Development Facilitation Team (DFT) – Review Comments

Project No: PR-2024-010949 Date: 11/13/2024 Agenda Item: #3 Zone Atlas Page: B-14

Request: Create two new tracts from one existing tract

Application For: SD-2024-00159- PRELIMINARY/FINAL PLAT

Plat for
Tracts B-5-A-1-A and
B-5-A-1-B, Cottonwood Mall
Being Comprised of
Tract B-5-A-1
Cottonwood Mall
City of Albuquerque
Bernalillo County, New Mexico
October 2024

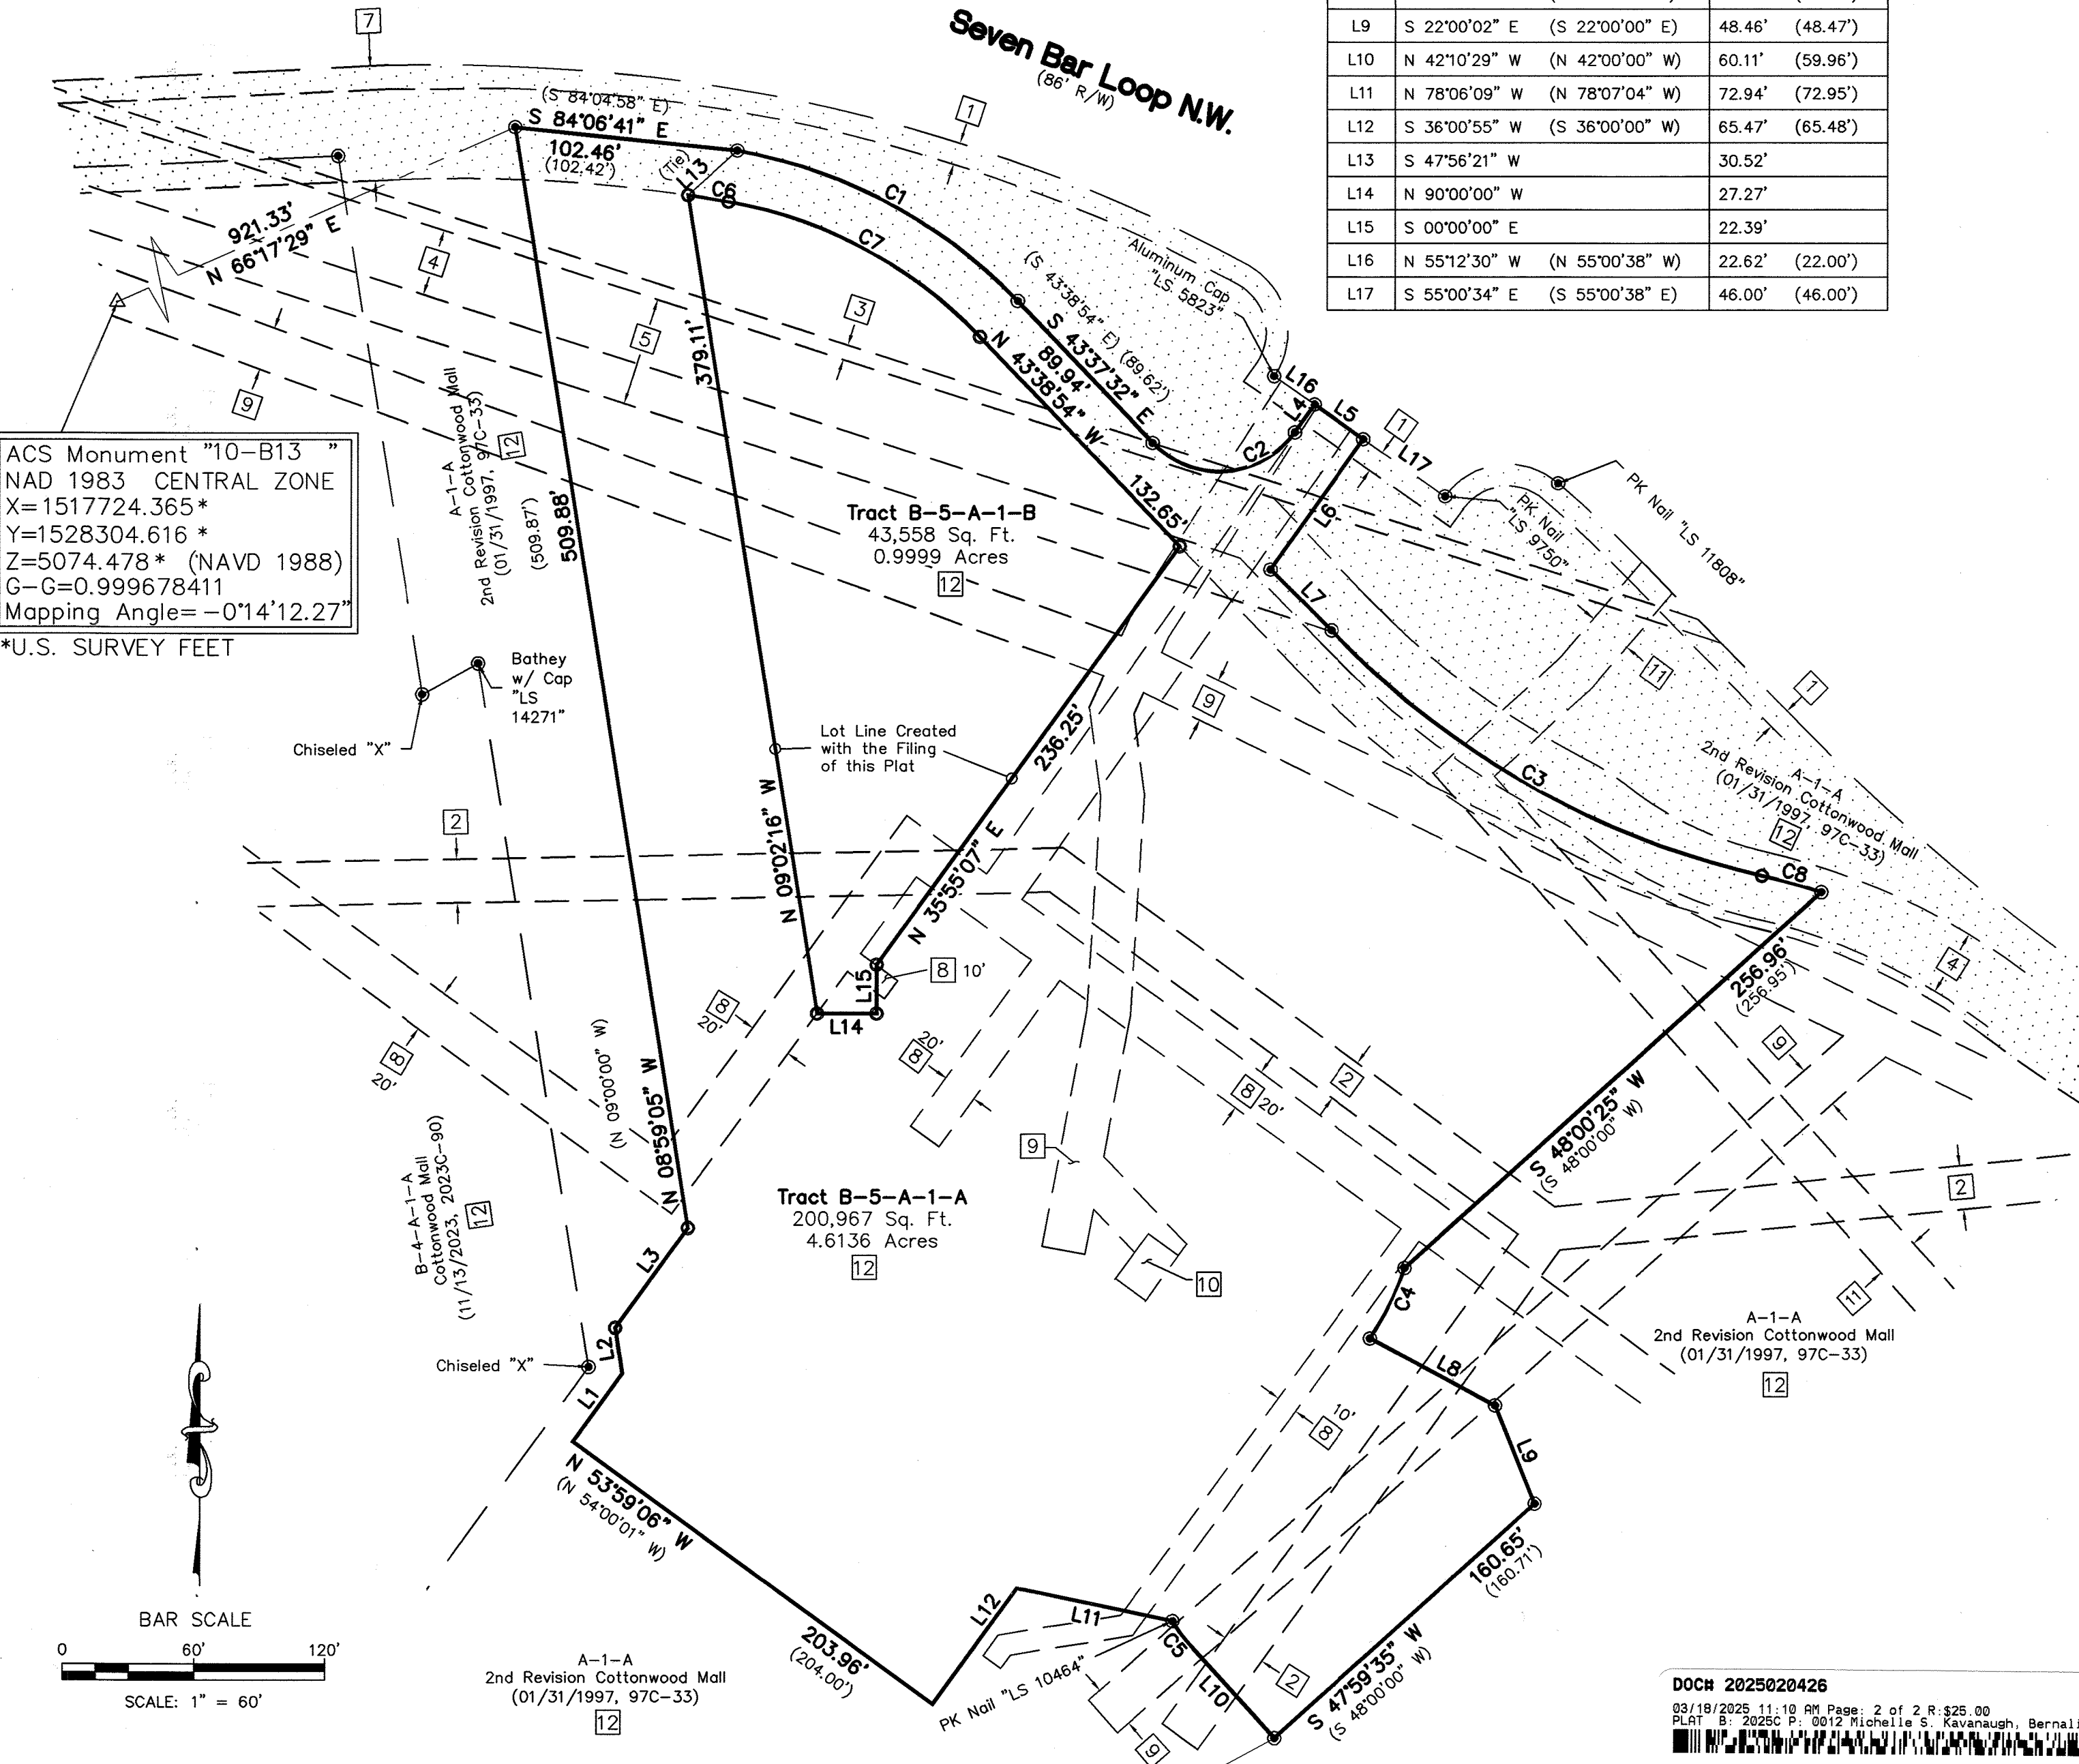
- Application number must be added to the plat.
- Prior to final sign-off of the plat, the AGIS office must approve the DXF file and proof of approval must be provided.
- Per 6-6(L)(2)(d)(7) of the IDO, the date of the DHO approval shall be recorded on the Plat. Therefore, prior to final sign-off of the Plat, the date of the DHO approval must be added to the Plat.
- Clarify compliance on the Site Plan with Section 7 of the *DPM* Table 7.2.29 regarding Sidewalk/landscape buffer zone width requirements along Seven Bar Loop Rd NW. Per Transportation comments in response letter; it states that the Roadway does not have appreciable frontage with Seven Bar Loop. Therefore, it was determined at the DFT meeting that sidewalk was not a concern for the new created tract.
